04/11/2020

**Western Sydney University Bankstown City Campus (SSD-9831)
Request for Additional Information**

I refer to the Amended Development Application (DA) and Response to Submissions (RtS) for the Western Sydney University Bankstown City Campus (SSD-9831). After careful consideration, the Department is requesting that you provide additional information.

DRAWING TITLE
SITEWORKS AND STORMWATER DRAINAGE PLAN-SHEET 1

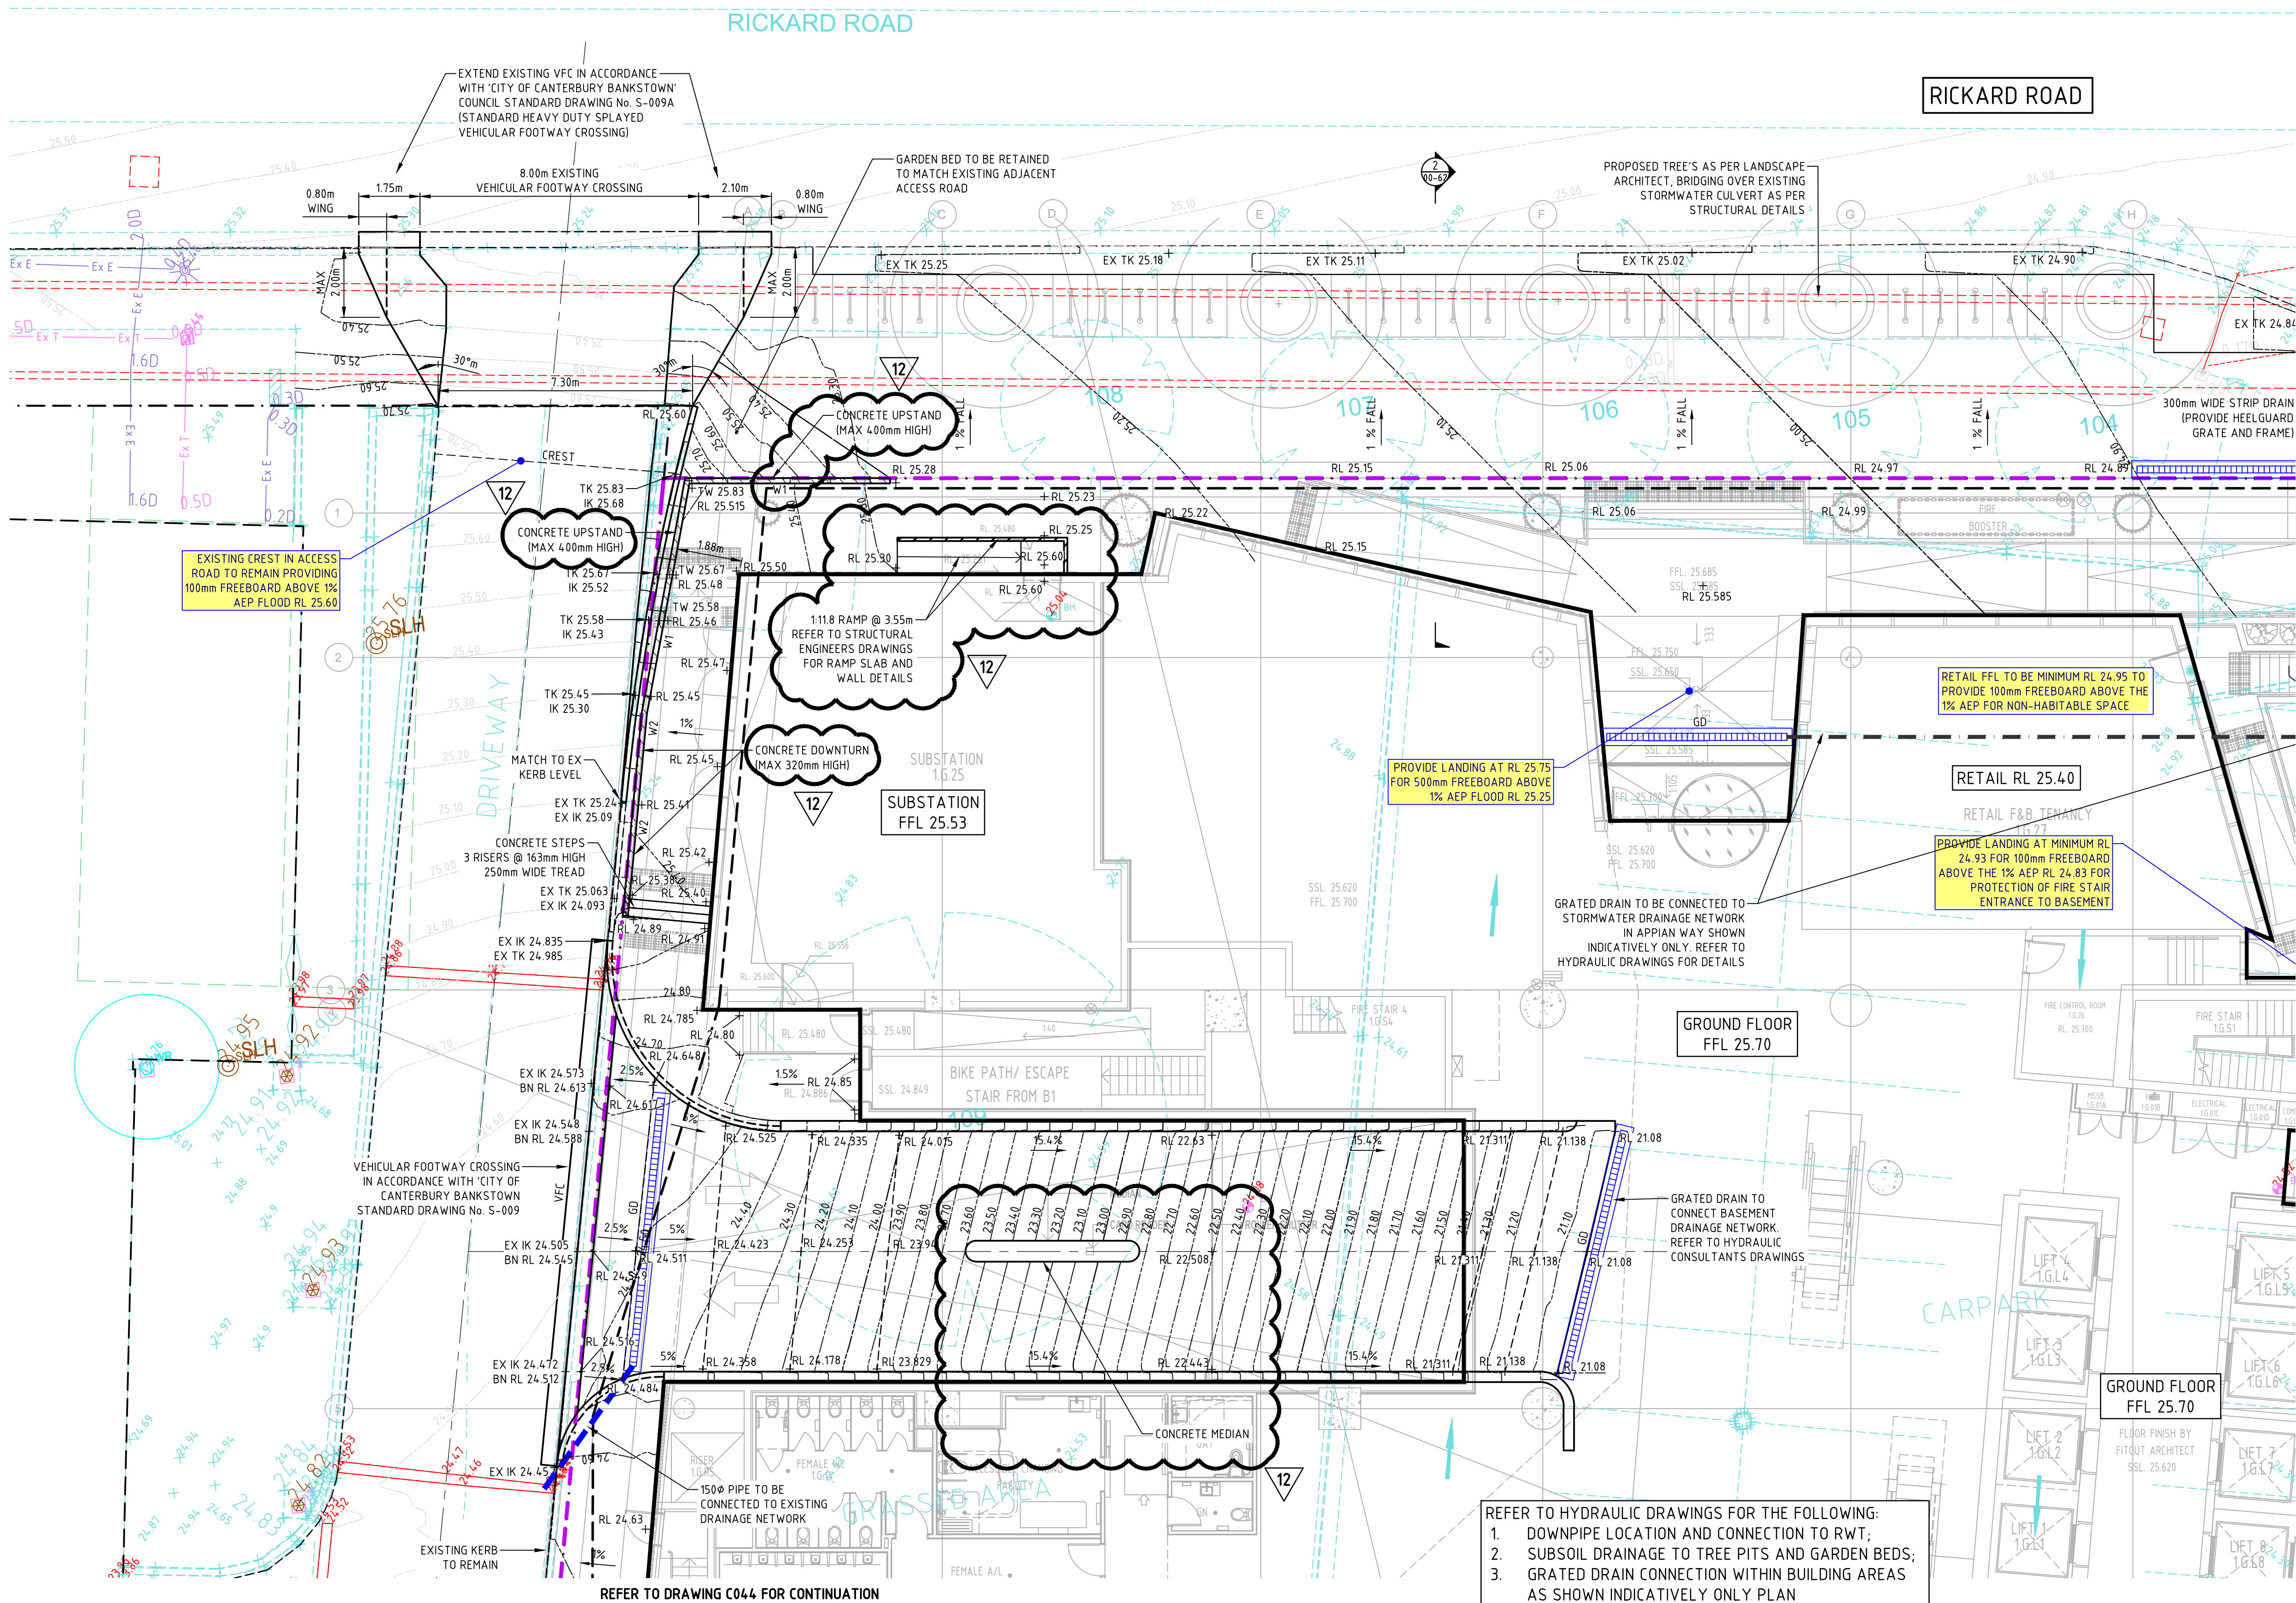
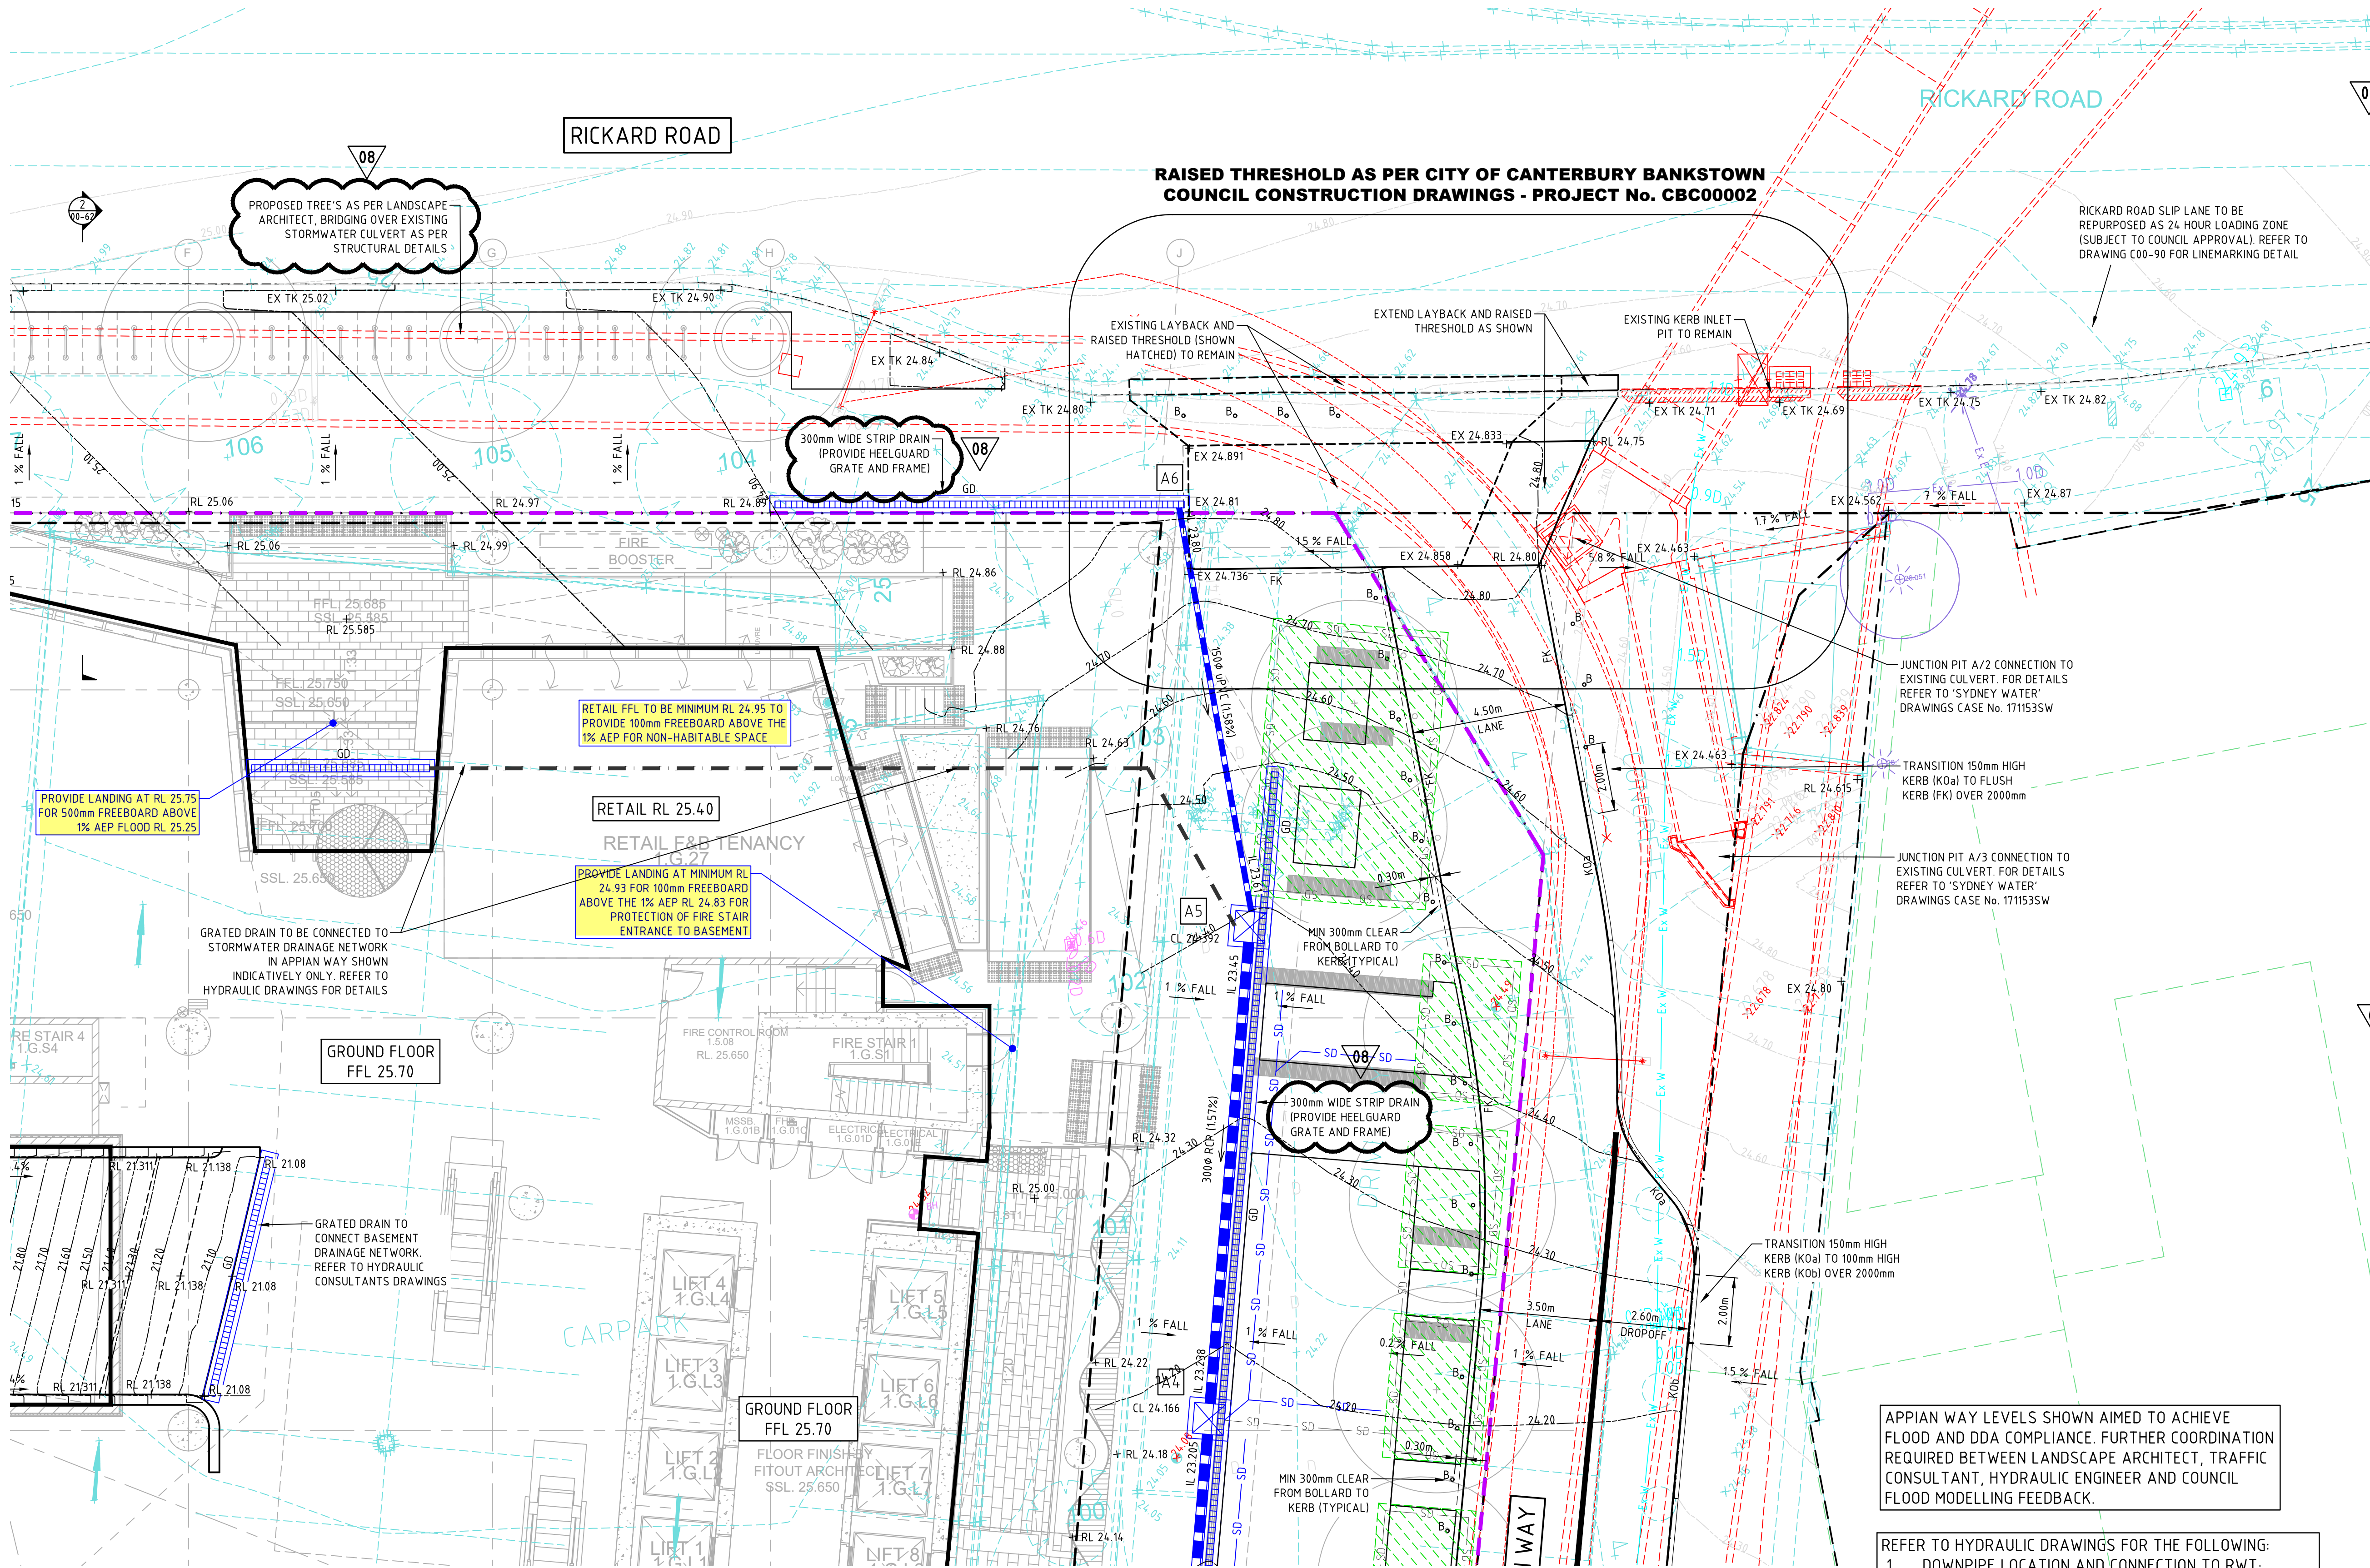
- Address risks to the basement as identified by Council, and provide additional information on finished floor levels and basement entry levels to address the matters raised by Council. Should revised modelling results permit, lower ground floor levels where possible.

74 RICKARD RD.
BANKSTOWN NSW 2200
DRAWING TITLE
DETAILED ELEVATIONS PODIUM 1

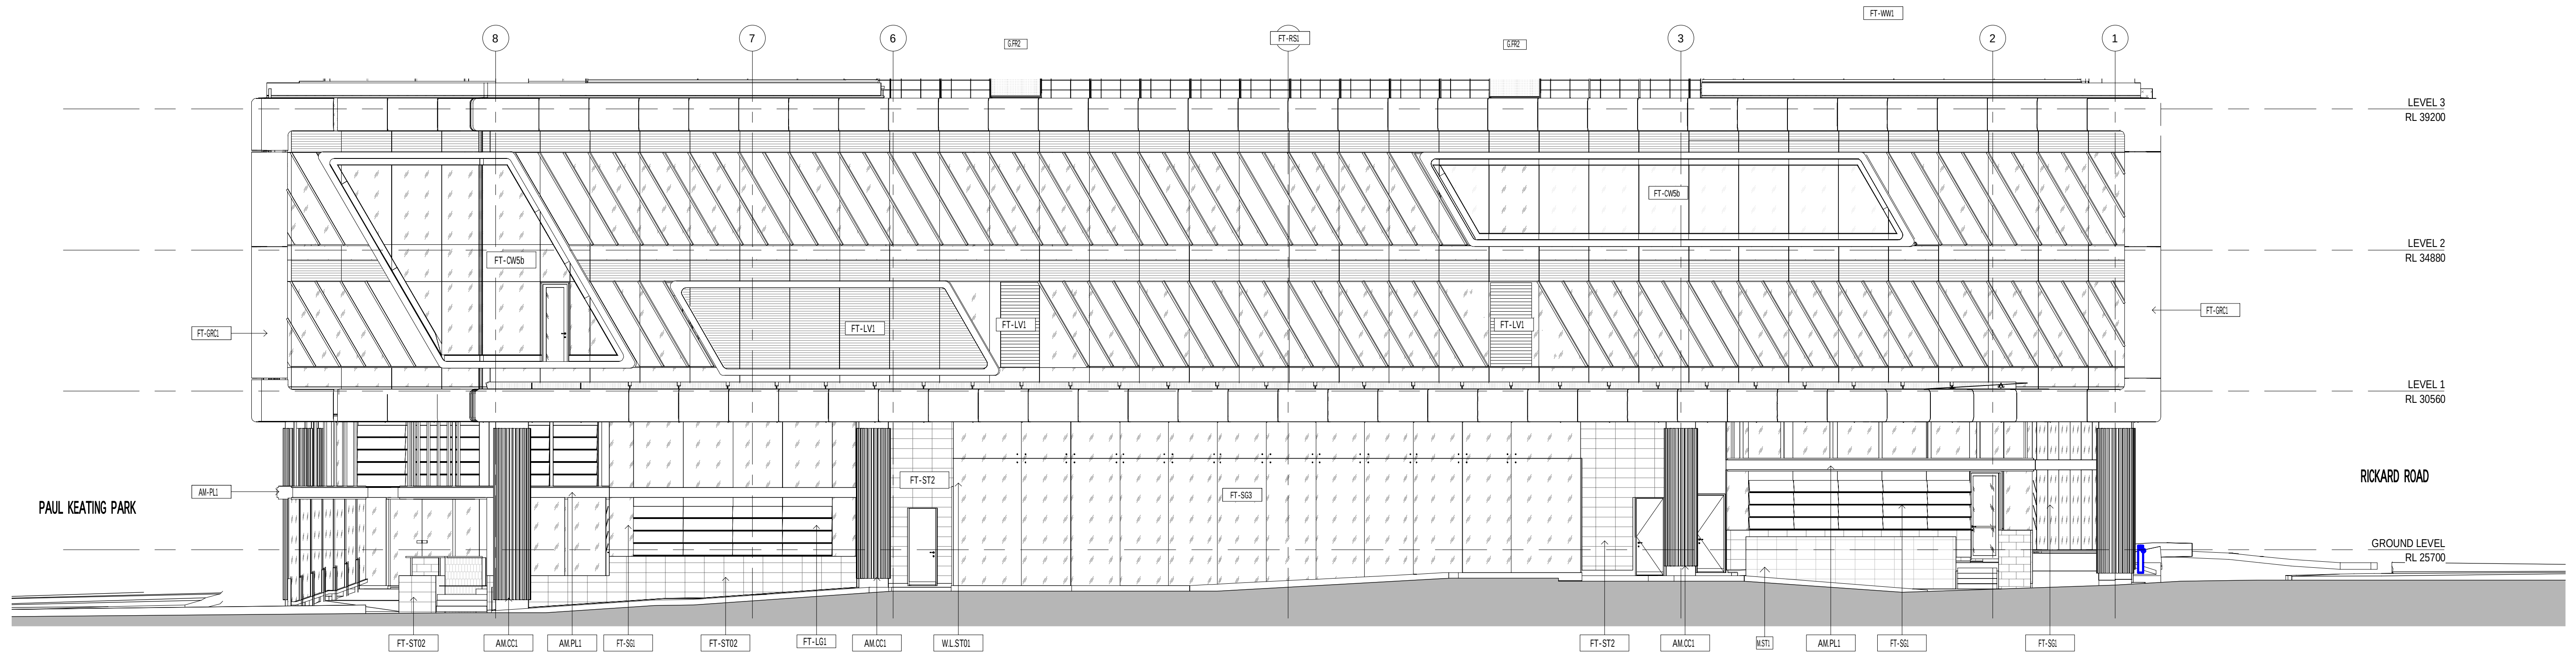
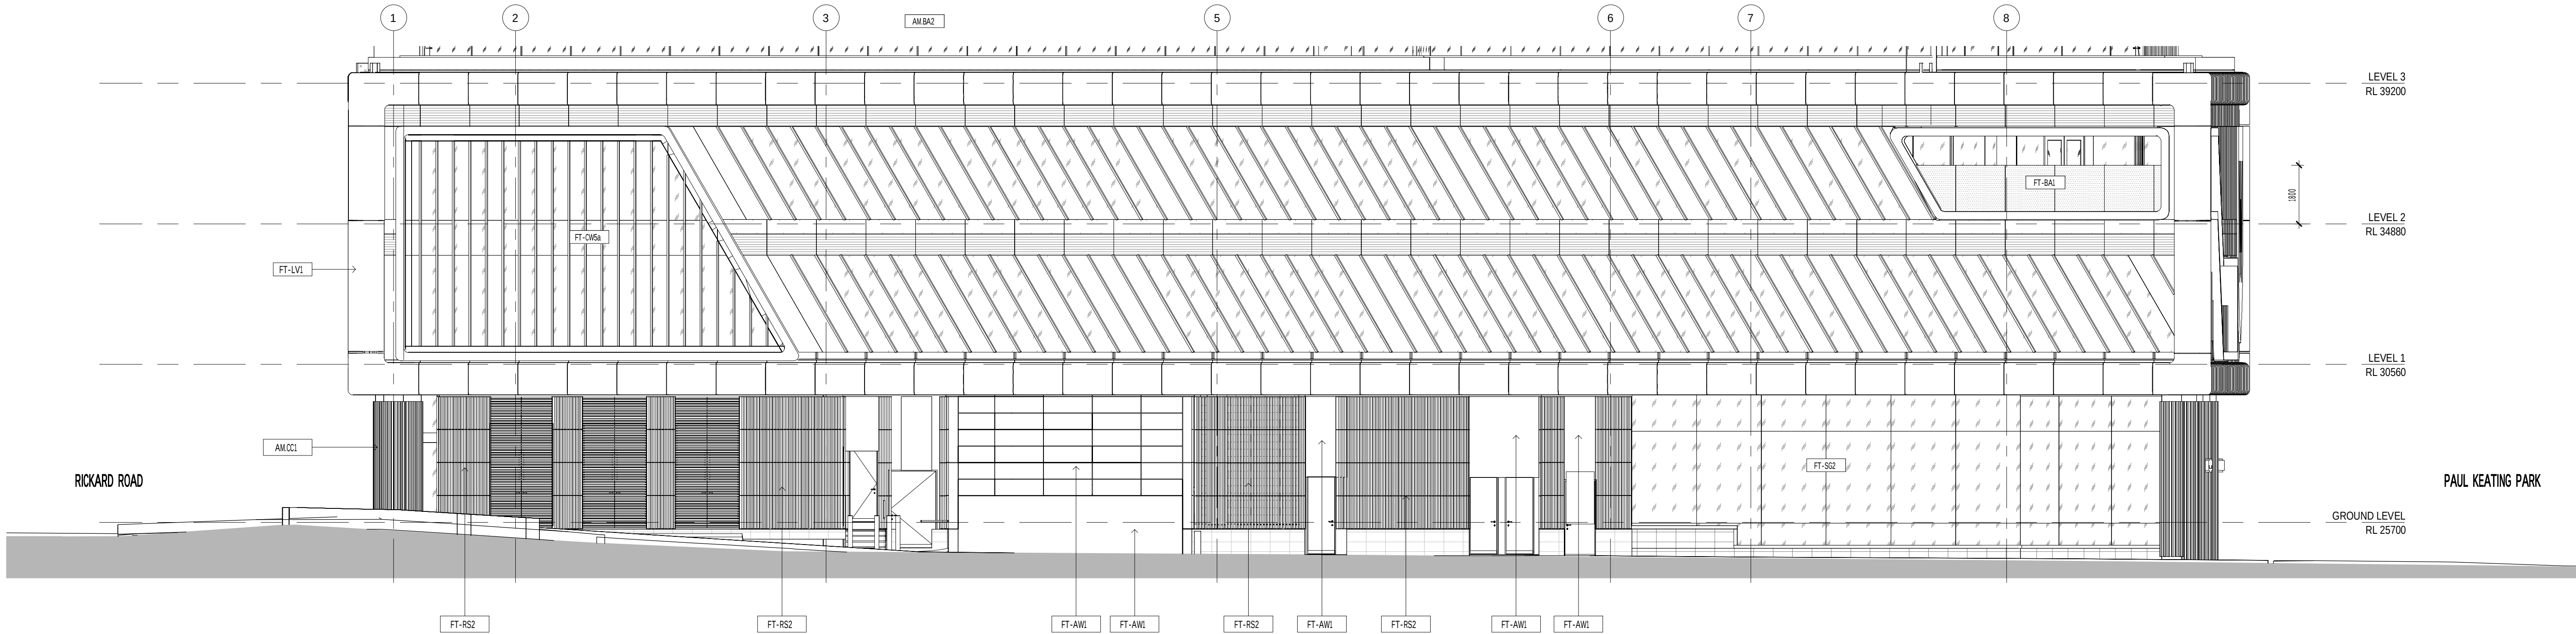
- *Where services such as fire escapes, service doors and equipment hatches / fire boosters cannot be avoided on ground level facades, elements of visual interest, such as display cases, or creative use of materials must be incorporated into the design.* Advise how this is achieved and include on the elevations.

- Update the elevations to label all elements and materials used in the ground floor facades. The Department notes the Appian Way elevation does not label the proposed materials and finishes at the ground level and therefore the extent of visual permeability is unclear having regard to the active street frontage controls of the proposed DCP.
